Response to Planning Application

Application ref: BE/4/22/DOC

Description: Approval of details reserved by condition imposed under hybrid application BE/135/18/PL relating to Full Condition Nos 3 - materials & finishes, 4 external lighting, 10 - hard & soft landscaping, 12 - surface water drainage, 16 - foul drainage, 21 - CCTV, 28 - acoustic fencing, 30 - security fencing and 45 - levels.

Location: Unit 9 Salt Box Field Land off Rowan Way Bersted PO22 9NW

PROJECT | ORIGINATOR | ZONE | LEVEL | TYPE | ROLE | NO.
114378-CAL-XX-XX-DR-D-0201

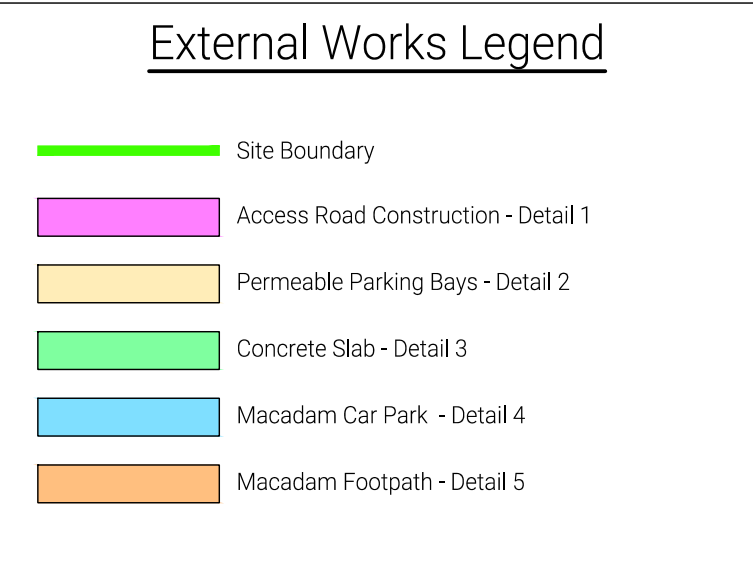
Detailed submission of information has been submitted in Calcinotto drawings 0200-T2 and 0201-T1 re proposed levels and external finishes, roadways and parking areas, which appears suitable for application and location.

- Tarmacadam finish throughout site, colour black - White lining / parking spaces, Thermoplastic white paint throughout
- Soft landscaping - Grassed areas to verges around site adjoining footpaths
- Paved areas - Marshalls 'Conservation Smooth' paving slabs, colour 'Silver Grey', size 400mm x 400mm x 65mm

Recommend discharge of Condition 10 hard & soft landscape detail under this application BE/4/22/DOC imposed under hybrid application BE/135/18/PL.
